Ribble Valley Borough Council  
Housing & Development Control

Your ref: 3/2023/0866  
Our ref: D3.2023.0866  
Date: 5<sup>th</sup> December 2023

Application no: **3/2023/0866**

Proposal: **Proposed five-bedroom, two-storey dwelling with a room in the roofspace.**

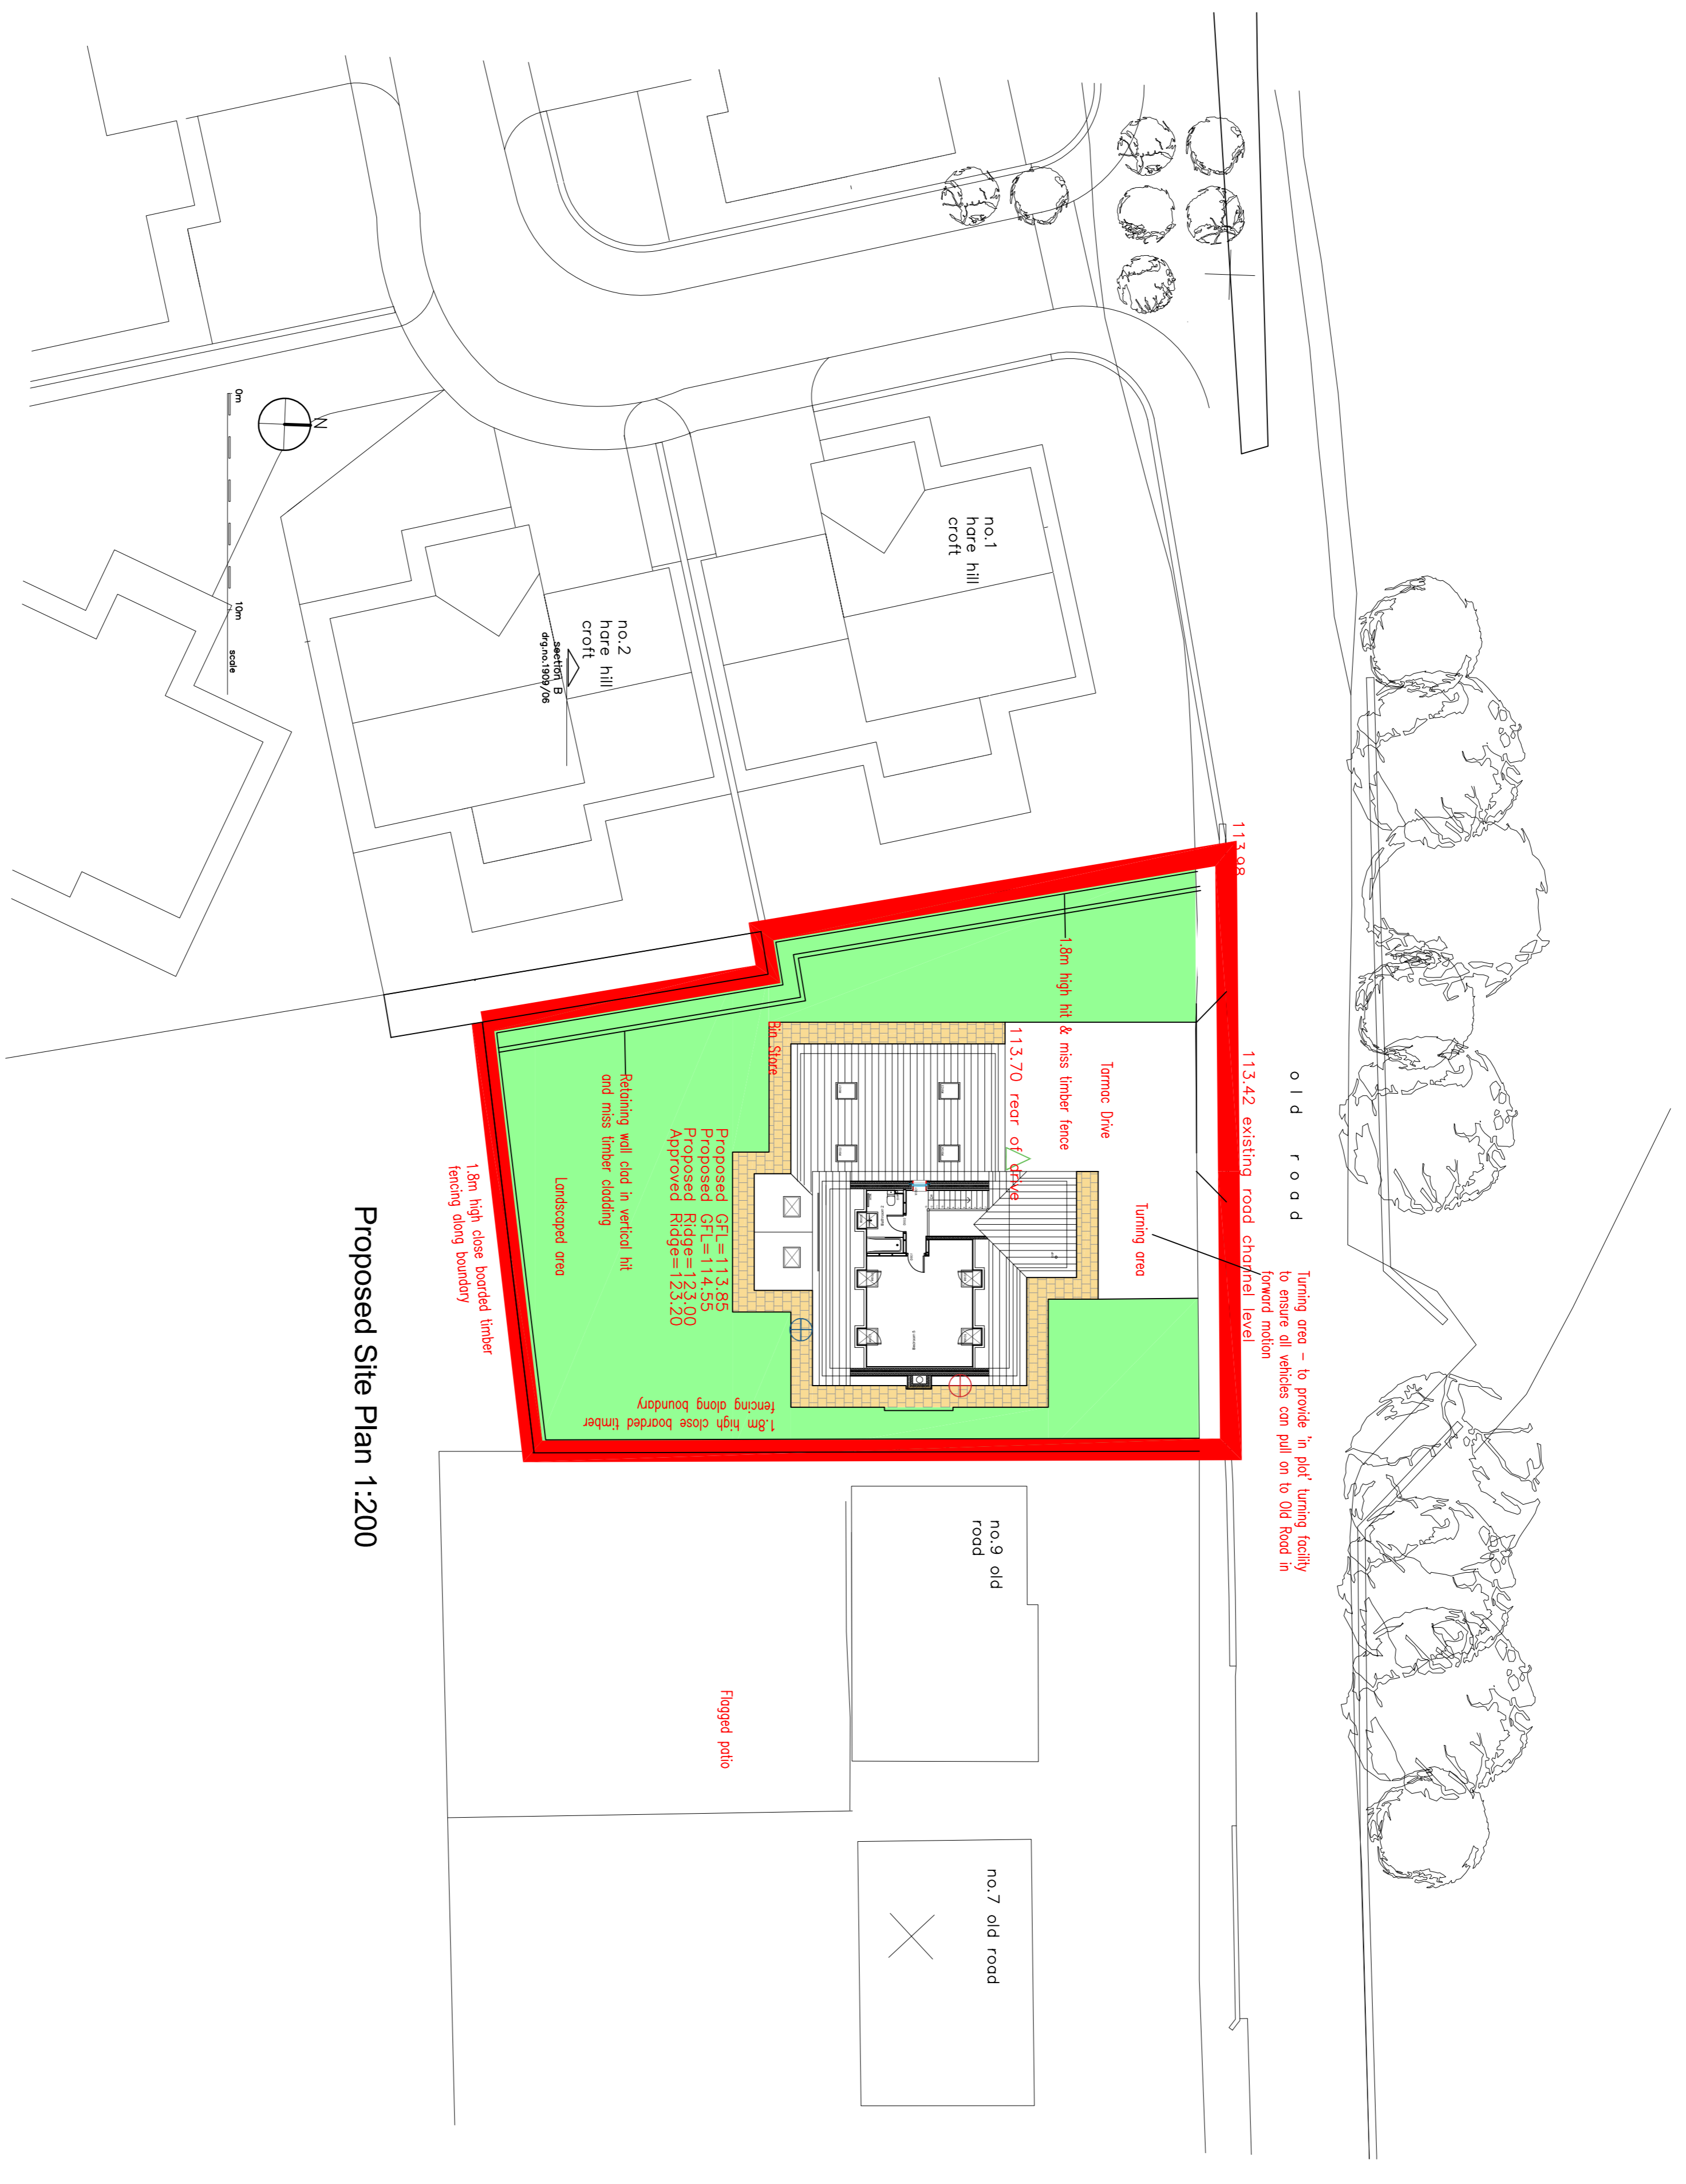
The LHA have reviewed the supporting documents and require further information regarding which site access will be used. This is because the Applicant/ Agent has provided drawing number COR/Plot 11/SP titled "Housetype Substitution Site Plan" and Site Plan 1, 2 and 3 as titled on the Local Planning Authorities planning portal which show different vehicular access arrangements. Therefore, further clarification is required.

Should the site use the access arrangements as shown on drawing number COR/Plot 11/SP titled "Housetype Substitution Site Plan" the LHA require the drawing to show the accesses maximum visibility splays. The LHA remind the Agent that the site should provide visibility slays of 2m x 43m in both directions to comply with national guidance.

The LHA remind the Agent/ Applicant that a 4 bed dwelling should provide a minimum of 3 car parking spaces to comply with the LHAs Joint Lancashire Structure Plan. Again, further clarification is required regarding which site plan will be used to support the application. However, should drawing number COR/Plot 11/SP titled "Housetype Substitution Site Plan" be used only 2 car parking spaces can be provided.

The LHA require further clarification regarding the site access and the parking arrangements. The principle of the development has already been permitted following application reference 3/2021/1153. But the supporting documents for this application, currently conflict with each other with the proposed access arrangements differing depending upon which drawing you are reviewing.
